Date: 03/13/2024

Re: **Framing Items**
Location: Lot 33 Wellers Knoll (269 Van Winkle Street Lillington, NC)
JDS Project No.: RDU2402687
Date of Inspection: 03/13/2024

A representative of JDS Consulting arrived on site to observe the issues reported to us by the client, which are presented, along with our recommendations, in this report.

FRAMING AT STAIRS w/  
OPTIONAL 3RD FLOOR

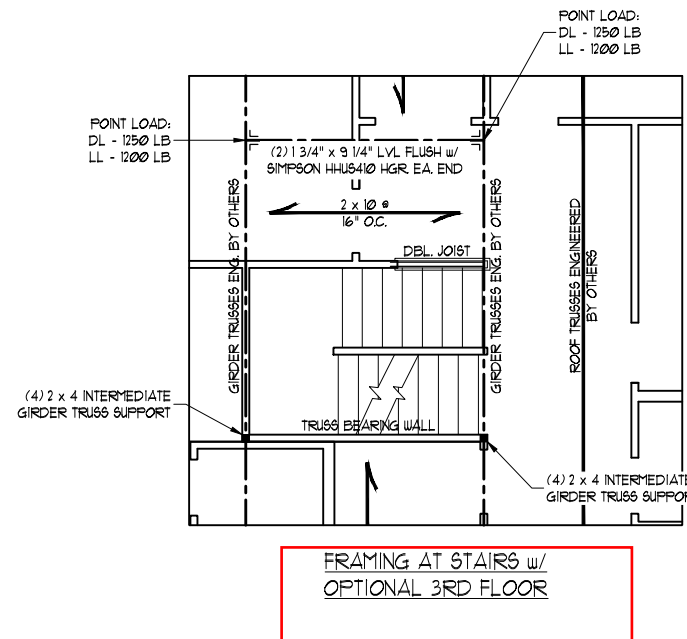
- 1) Inspector notes "2x10s at stair landing there is no option for 2x10s on the plans".
It was observed that the stair landing between floor 2 and 3 was stick framed with 2x10 joists, spanning 7', at 16" o.c. Joists are bearing on 2x4 wall studs, and nailed into a doubled stud on its side. 2x10 blocking was installed between each joist at their ends.
- 2) A06 2-PL truss has damaged gusset plates on both sides of joint 7.
- 3) F33 floor truss, 5th from left exterior wall. The bottom chord was cut at near joint 17 bearing end (member 18-17). Gusset plate on right was cut slightly as well.

- 1) 2x10 framing for stair landing is adequate as installed. No action is required.
- 2) Install a 24"x24"x7/16" OSB gusset plate on both sides of the truss. Cut edges of OSB flush with roof slope and ceiling/wall slope as necessary. Attach with minimum (14) 10d nails in the vertical web on each side, and minimum (14) 10d nails in the top chord on each side.
- 3) Install 3' long 2x6 scab on right side of F33 floor truss along bottom chord extending out from the rear end. Attach with (1) row of 10d nails through all covered members.
